Planning Department
David Campbell, Director

June 18, 2018

**Re: McDonalds - 8315 Montgomery Blvd NE
Tract A-1-F of the Los Pastores Shopping Center
Grading and Drainage Plan - Engineer's Stamp dated: missing (F19D013A)**

C8.1

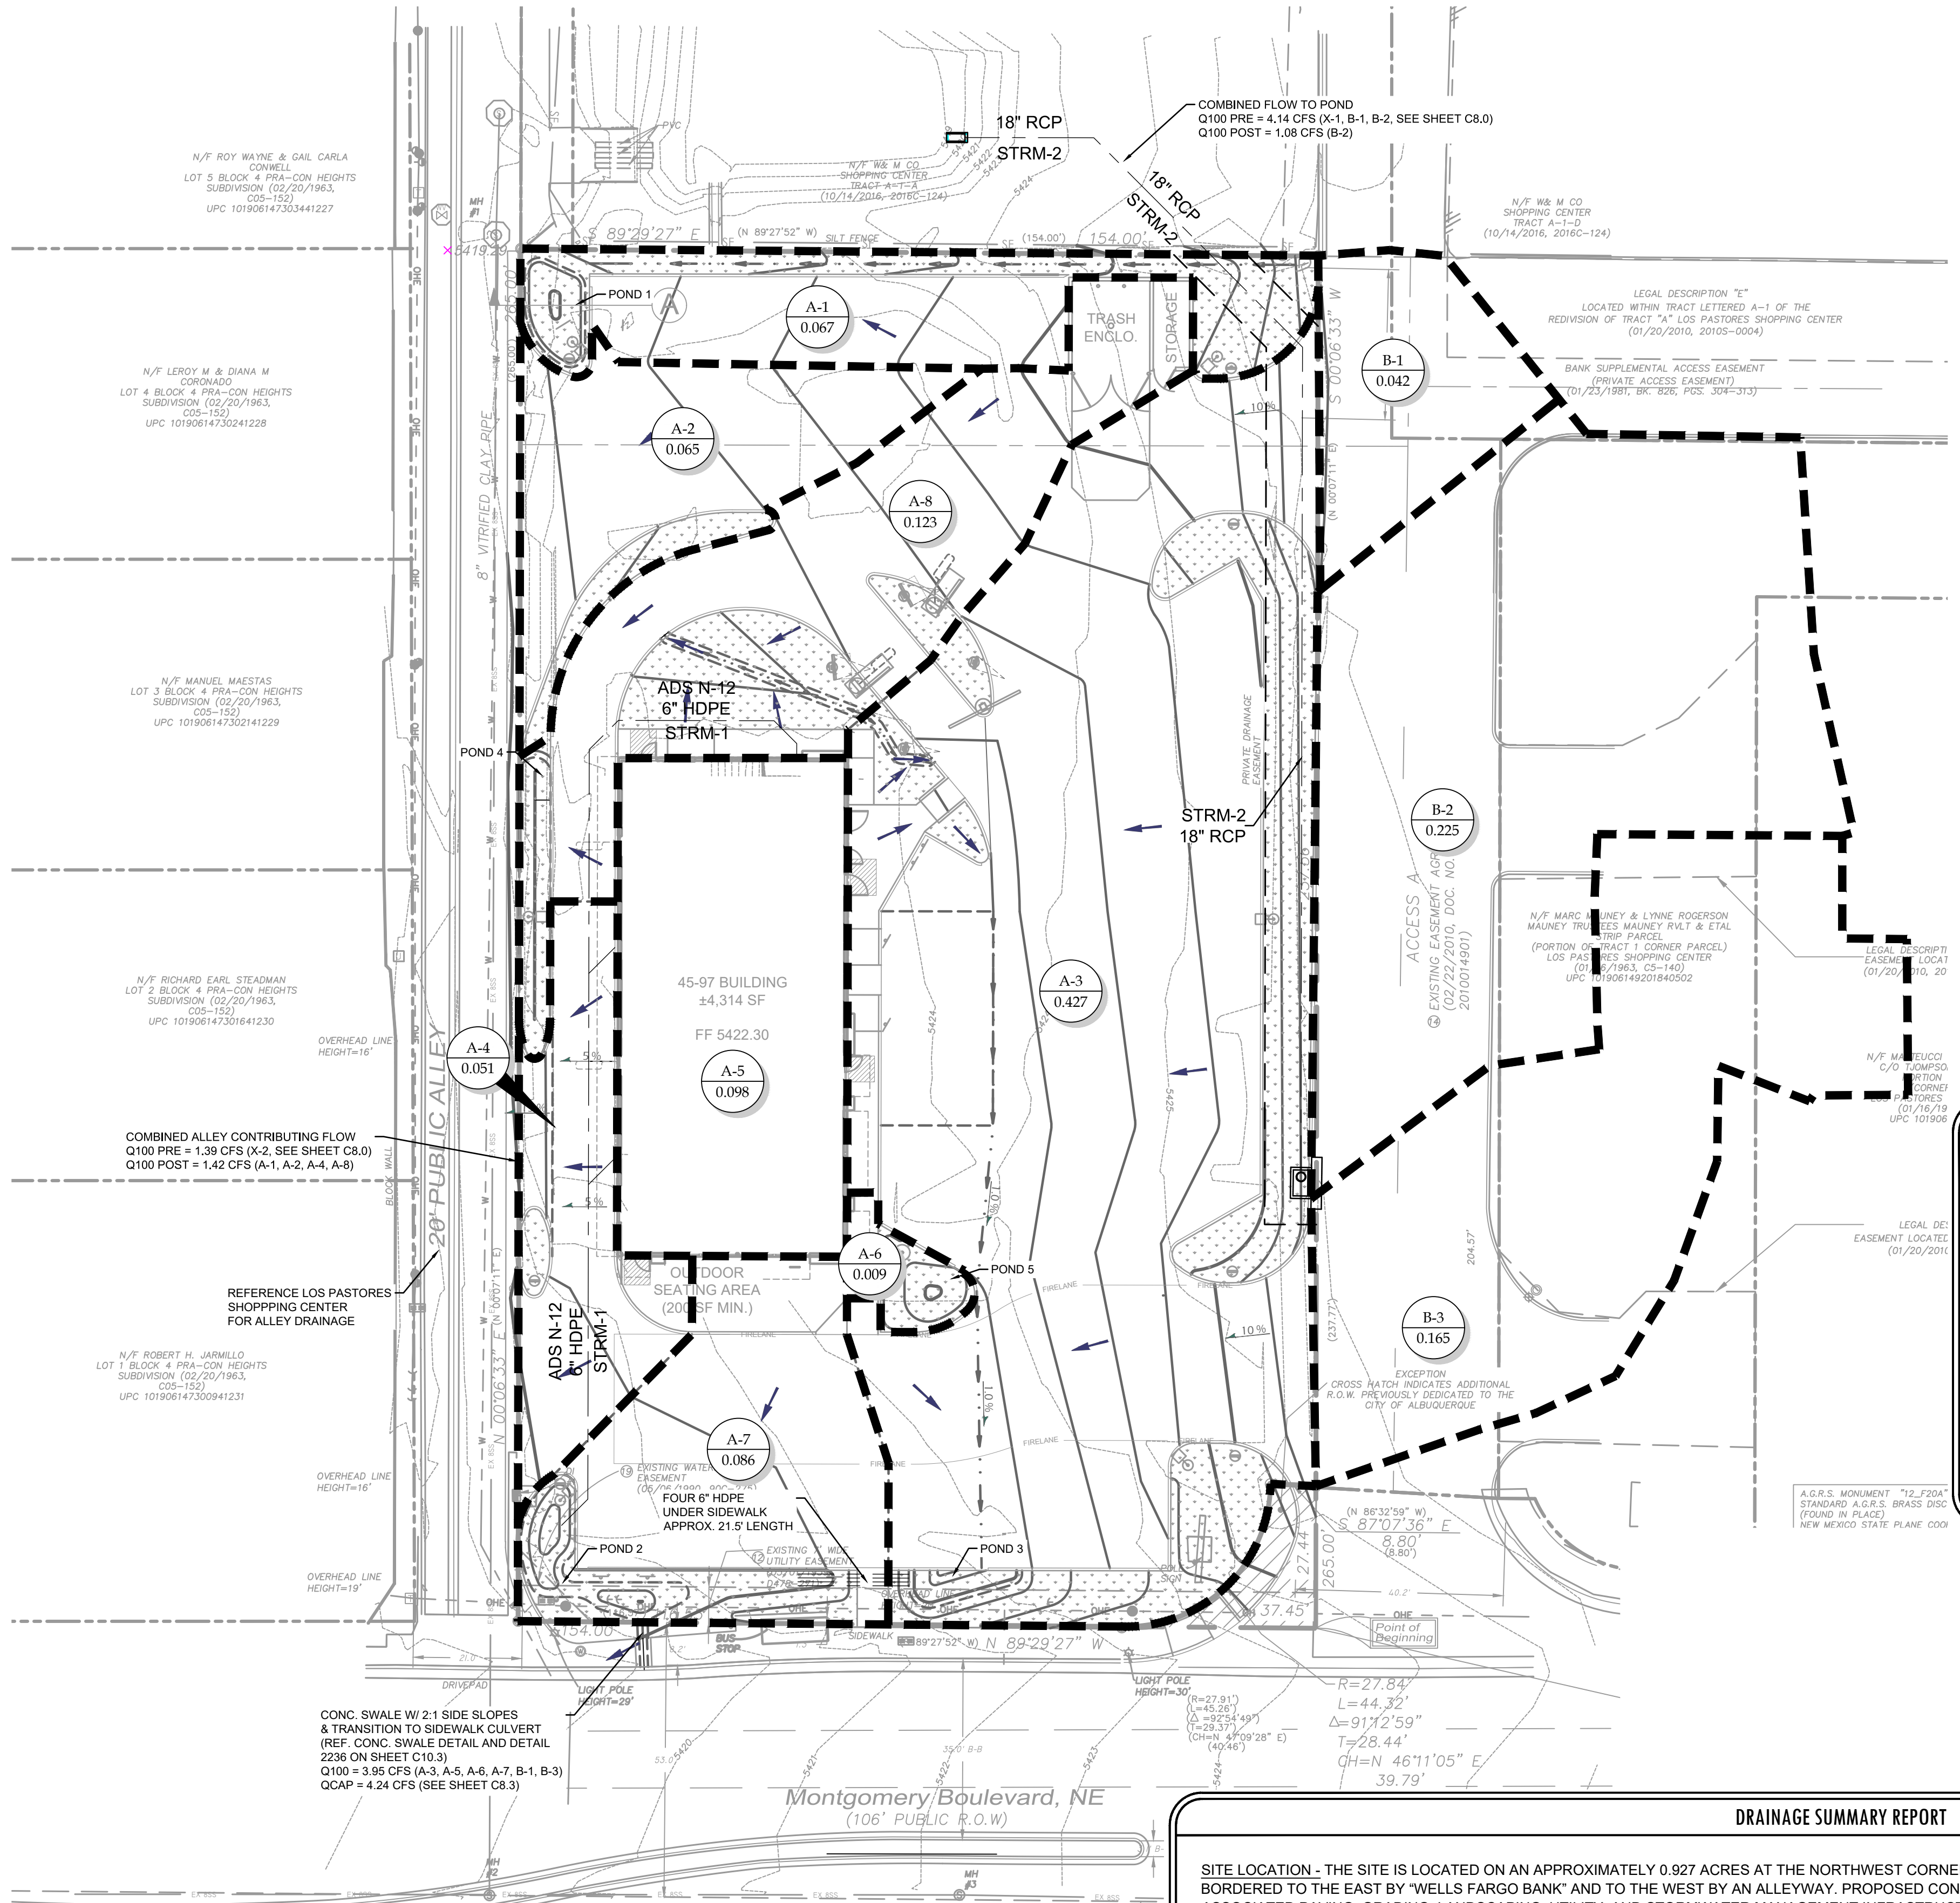
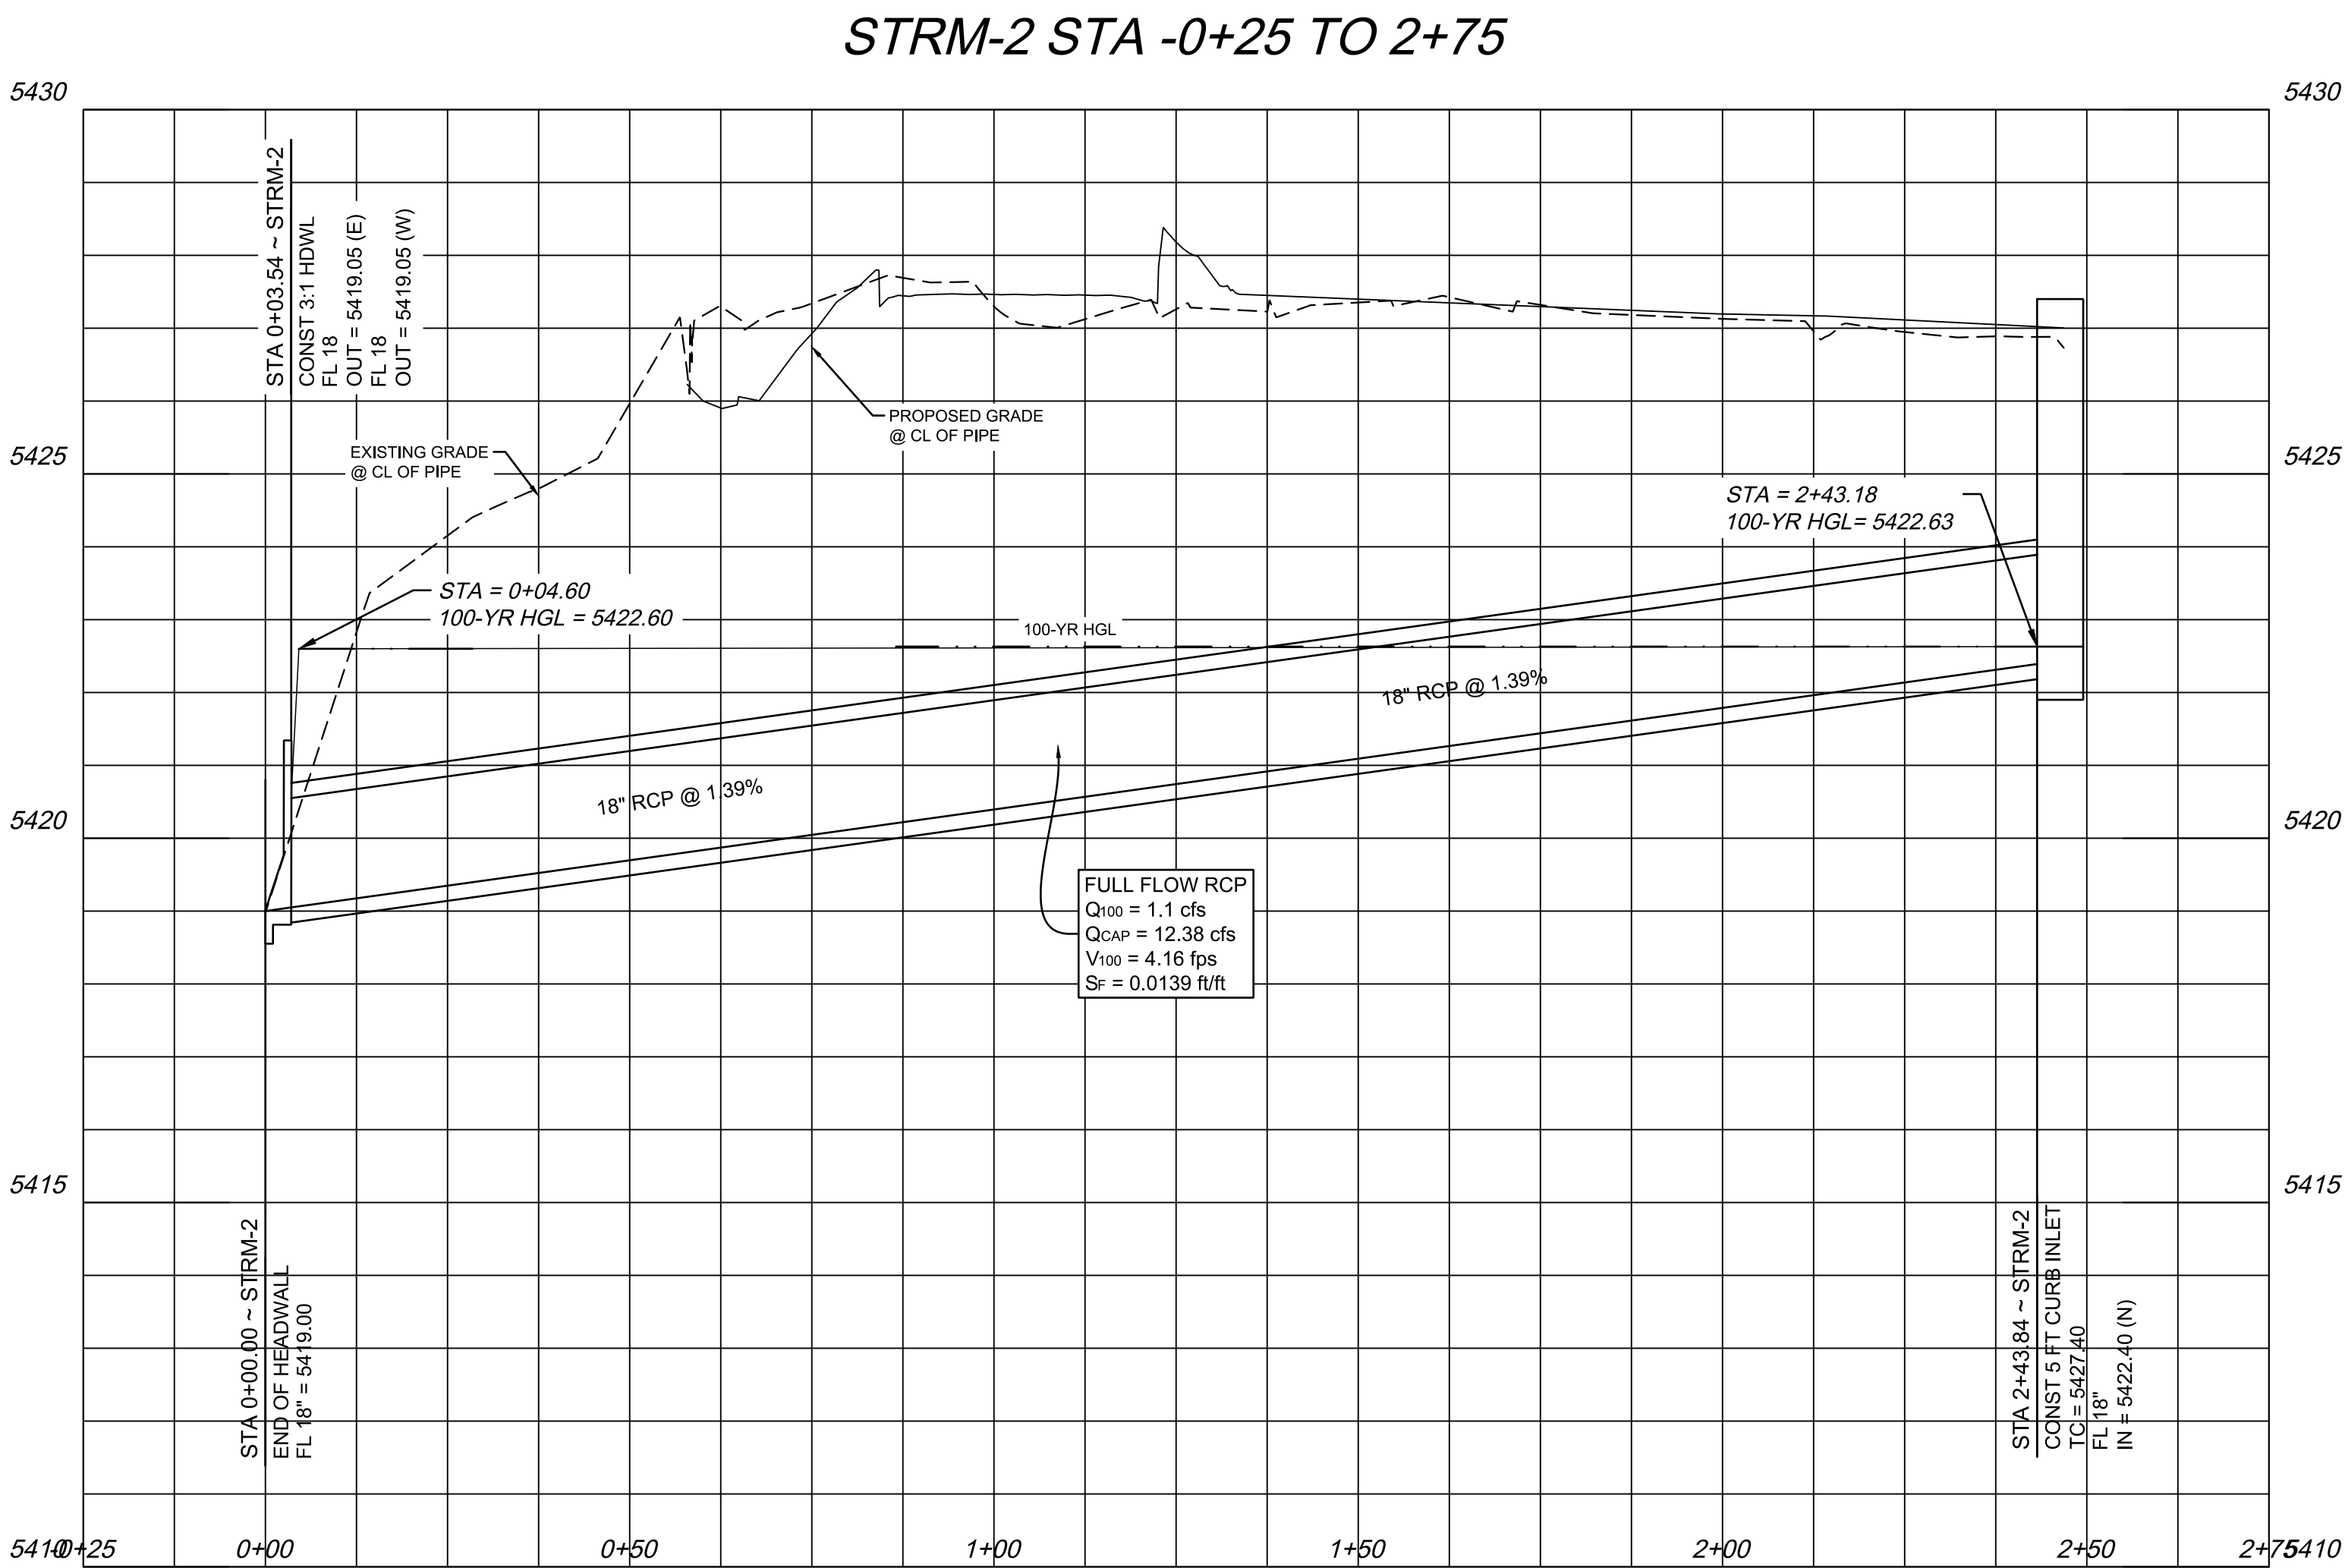
7. The drainage summary on sheet 8.1 says basin A-1 drains into the offsite detention pond but there is not sufficient detail to see how that drainage enters the pond. Instead it appears that the drainage enters Pond 1. A typical section is required thru the north and west boundary in association with Basin A-1 and Pond 1. The sections must include horizontal and vertical dimensions to the property line and show both existing and proposed grade.

8. Basin A-3 drains to 3 different ponds and basin A-6 drains to two different ponds. The drainage basin boundaries and areas must be revised to accurately identify the area draining to each first flush pond. The first flush requirements apply to all redeveloped impervious area on this site. Each pond should be sized for 0.26" of runoff from the impervious area draining to it. The City doesn't give credit for extra volume in a pond over and above that which is required for the impervious area draining into it. A waiver may be requested for redeveloped impervious surfaces not meeting the required first flush volume. The waiver request must state the area of impervious and the first flush volume and be located next to the pond volume calculations on the G&D Plan. If the waiver is granted the developer will be required to pay \$8.00/CF in lieu of constructing the required volume.

12. Existing Spot elevations are not legible. The minimum font size is 0.10". Dots show up instead of text around the perimeter of the site. The drainage summary on sheet 8.1 also has dots instead of text.
